**EL PASO COUNTY PLANNING AND
 COMMUNITY DEVELOPMENT
 DEPARTMENT**

SF-21-016

GRADING AND EROSION CONTROL PLAN CHECKLIST

ROLLING HILLS RANCH FILING 3

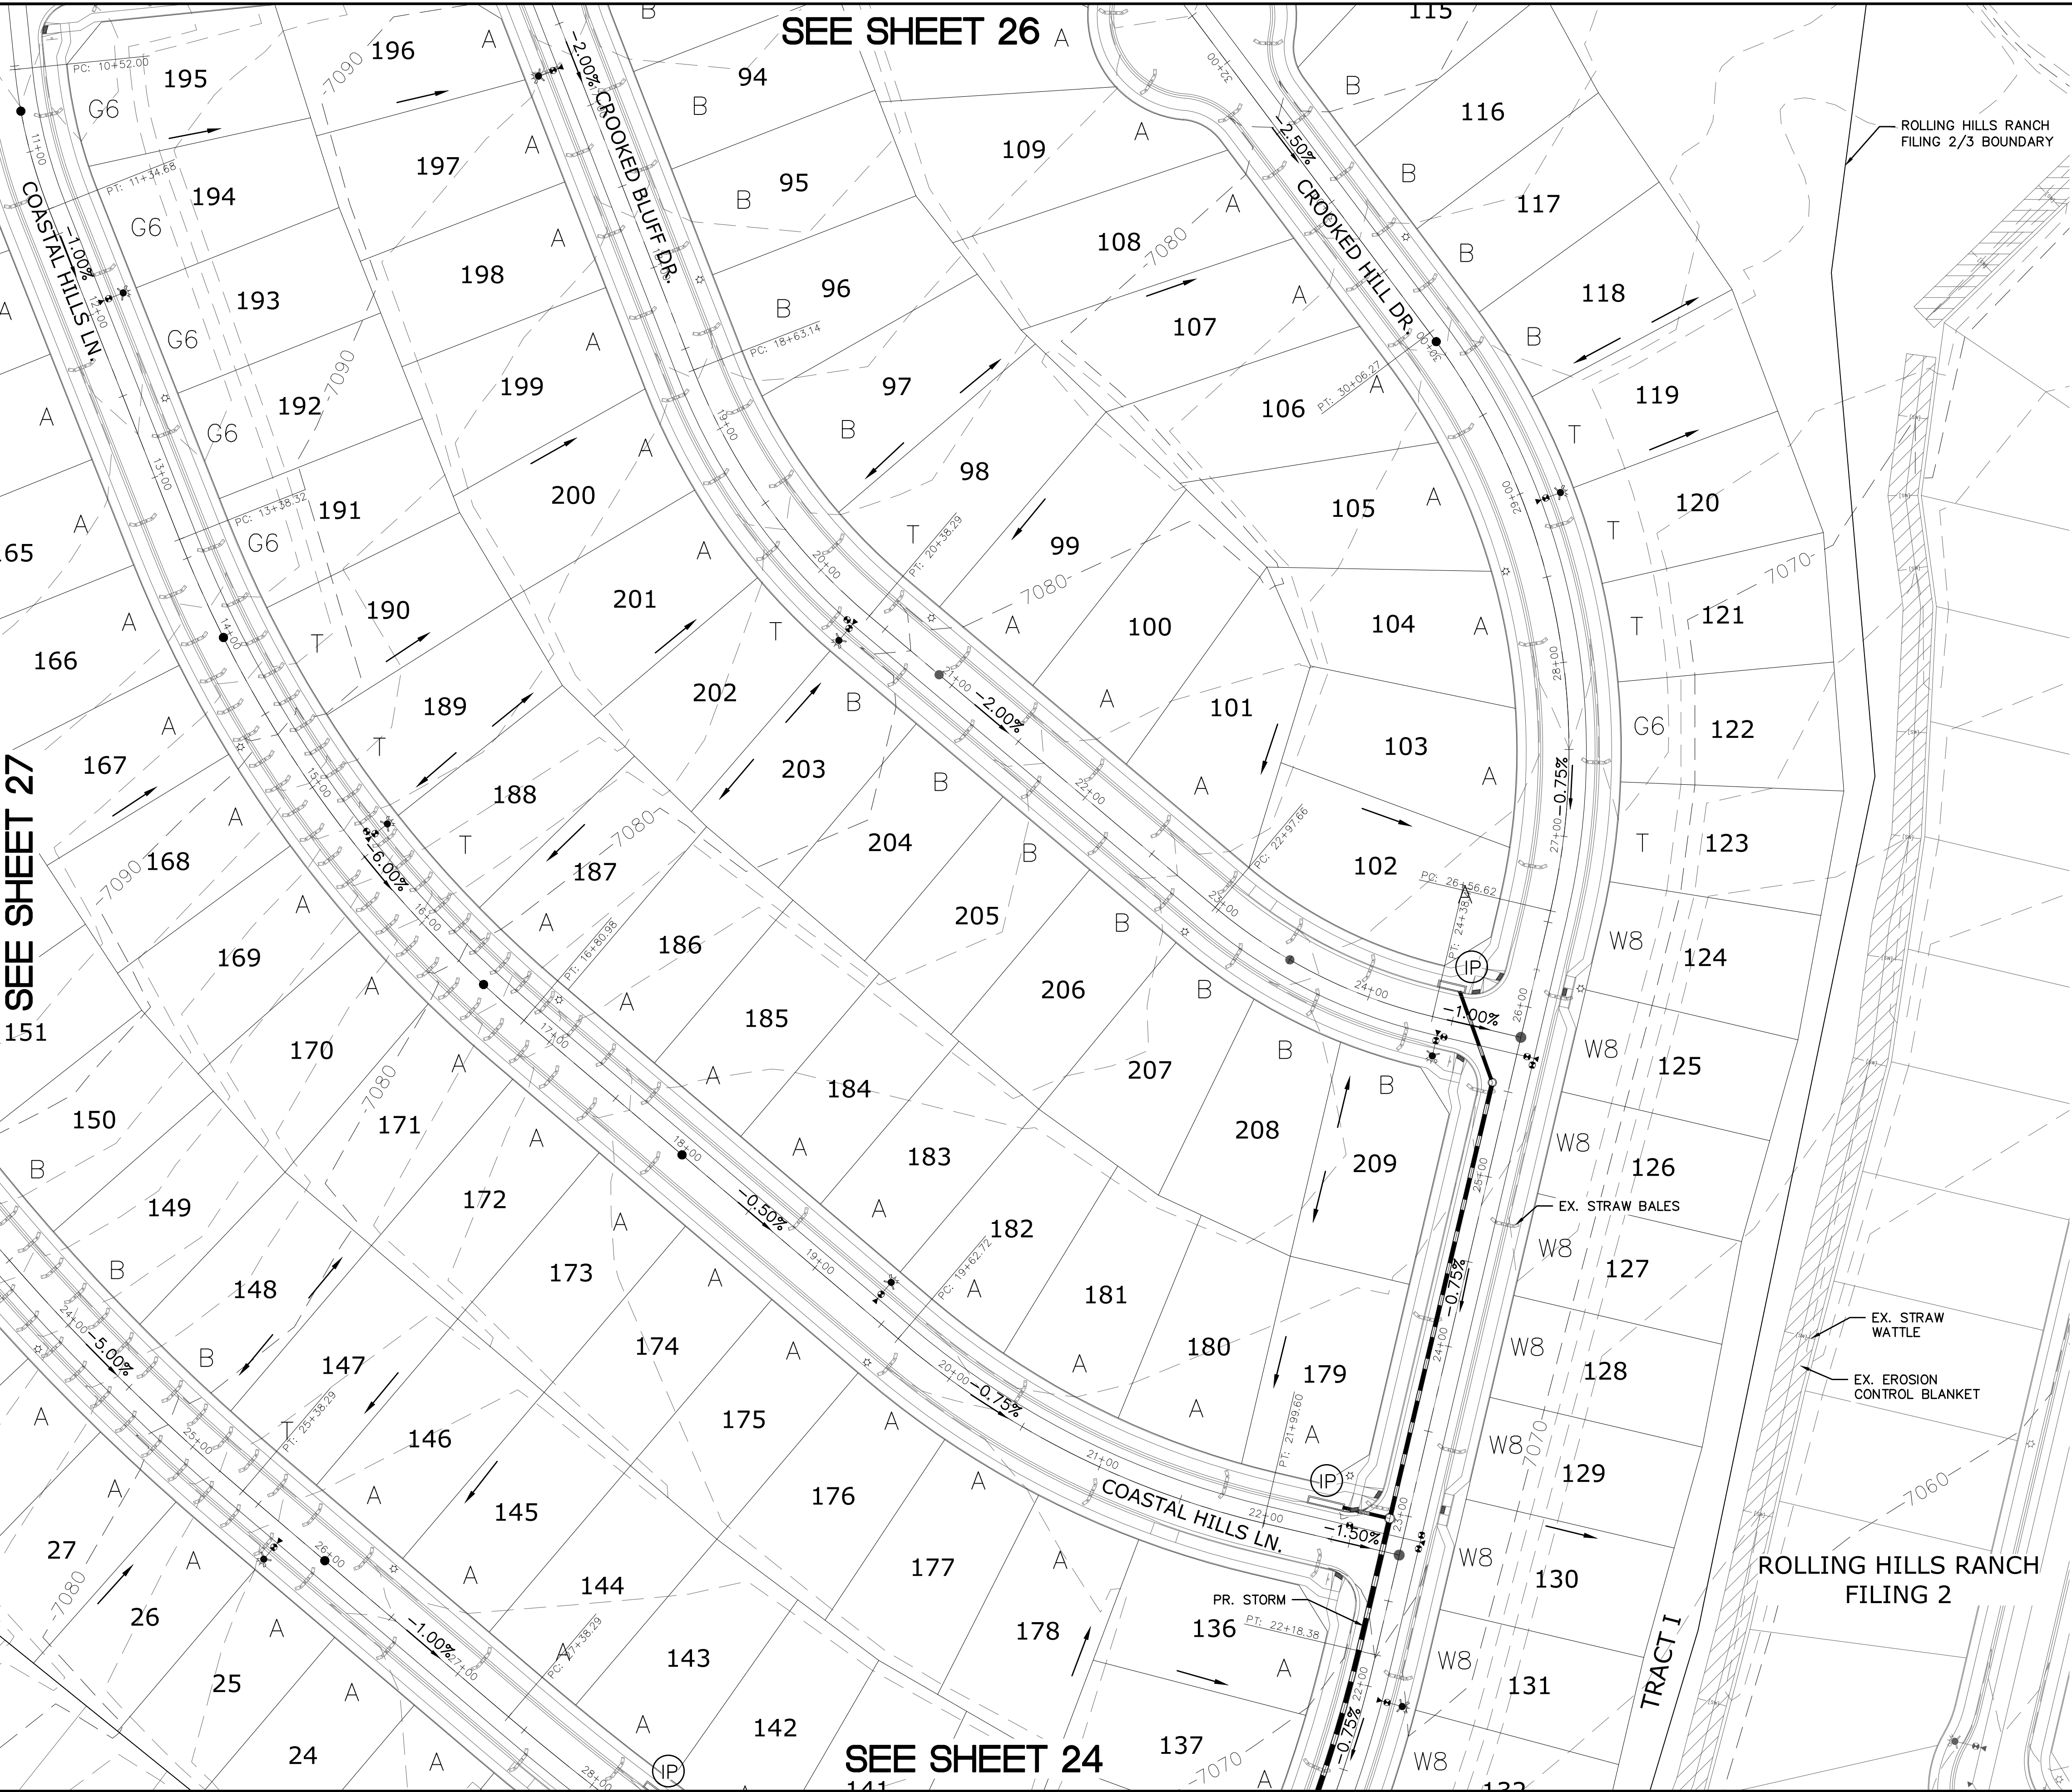
l	Existing Construction boundary line weight revised, no grading associated with the project, therefore no limits of grading to be shown.	X	Y
m	Limits of disturbance. See comment on Sheet 24	X	
n	Identify and protect areas outside of the construction site boundary with existing fencing, construction fencing or other methods as appropriate.	X	Y
o	Offsite grading clearly shown and called out.	n/a	N/A
p	Areas of cut and fill identified. Site grading already complete	X	N/A
q	Conclusions from soils/geotechnical report and geologic hazards report incorporated in grading design (slopes, embankments, materials, mitigation, etc.)	X	
r	Proposed slopes steeper than 3:1 with top and toe of slope delineated. Erosion control blanketing or other protective covering required.	X	N/A
s	Stormwater flow direction arrows. Revise to N/A if true.	X	Y
t	Location of any dedicated asphalt / concrete batch plants.	X	N/A
u	Areas used for staging, storage of building materials, soils (stockpiles) or wastes. The use of construction office trailers requires PCD permitting.	X	Y
